CITY OF ALBUQUERQUE

September 2, 2016

RE: ~~6528 Azar NW~~ *912 OAK ST.*
Request for Permanent C.O. – Not Accepted
Engineers Stamp Date 11/11/15 (K15D047B)
Certification Date 9-1-16

C-102R

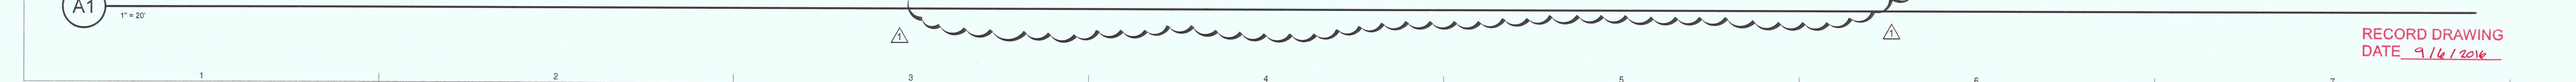
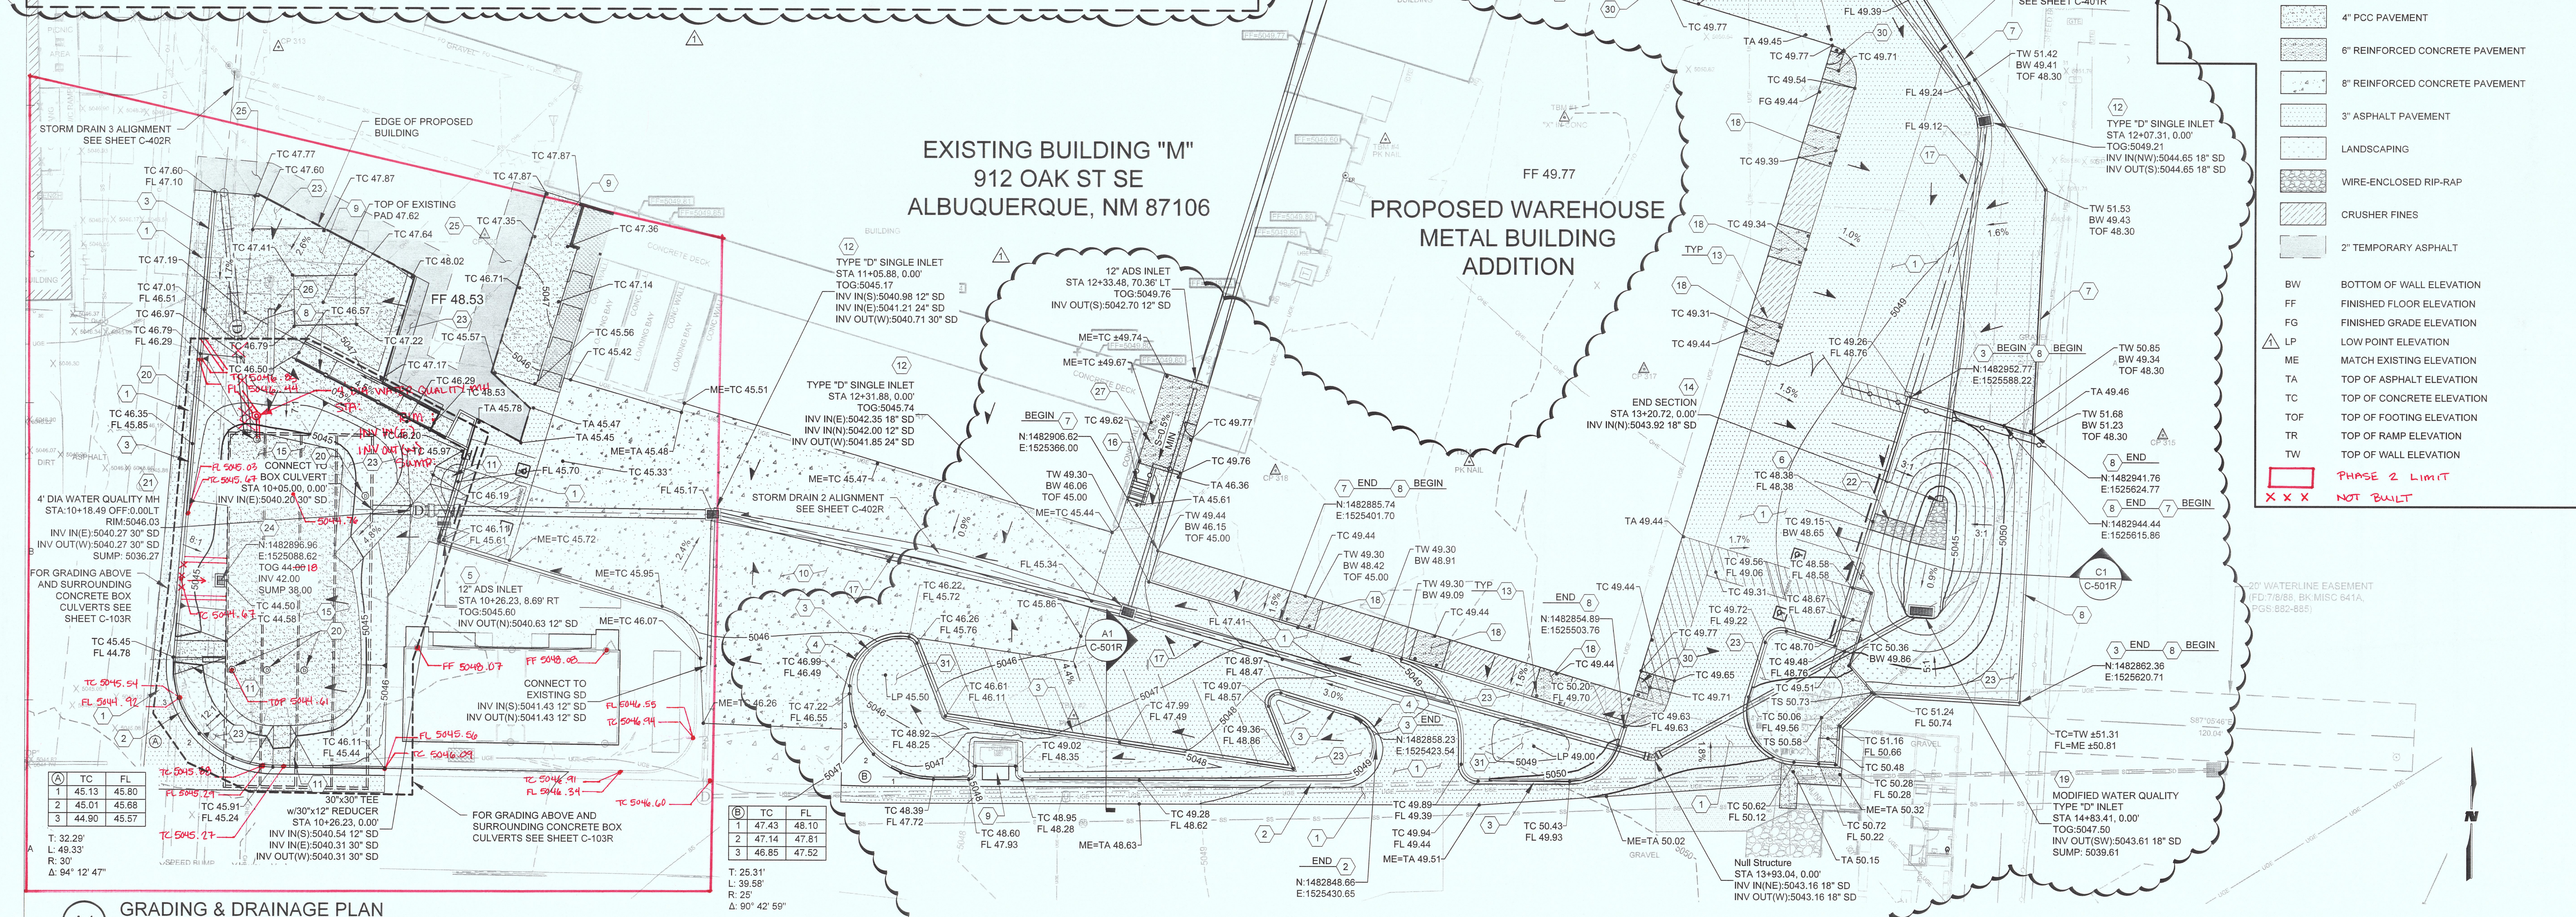
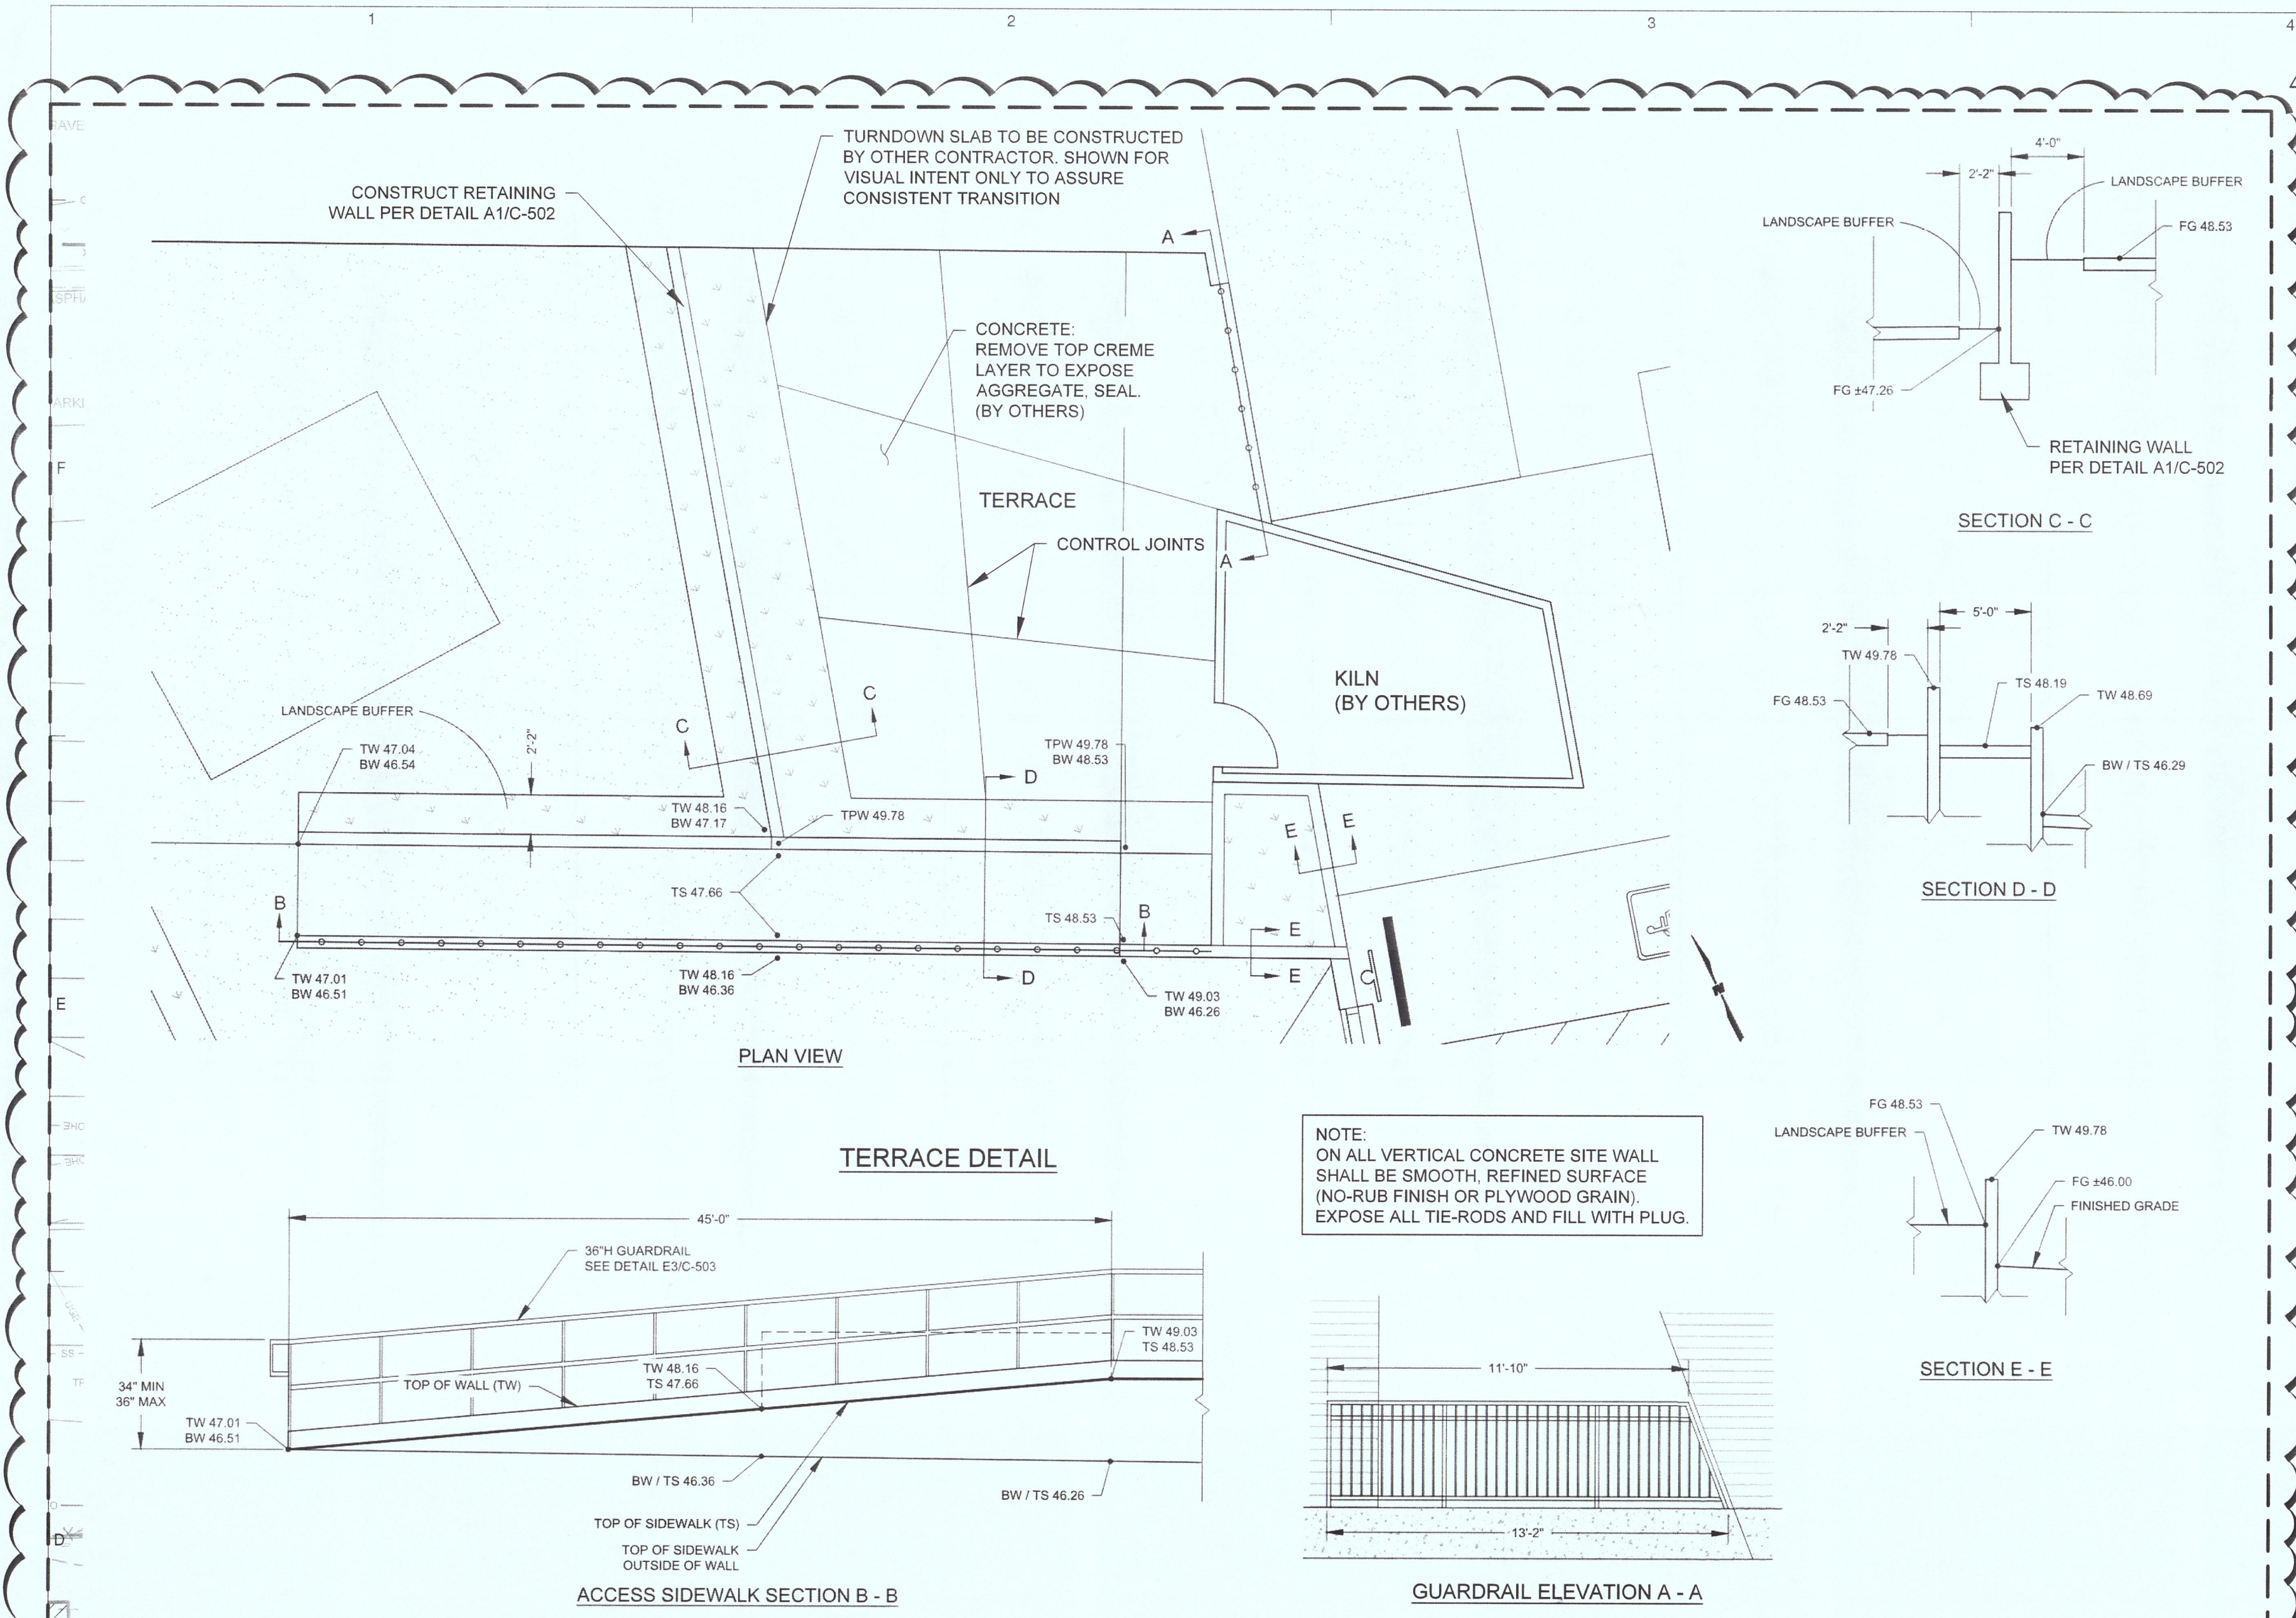
- Drawings for the complete Phase 2 were not included in the submittal.
- The Type "E" manhole (note #12) is missing.
- It is recommended that the swales be addressed as to not erode the pavement due to ponding that is already evident. Swales to not match approved drawing.
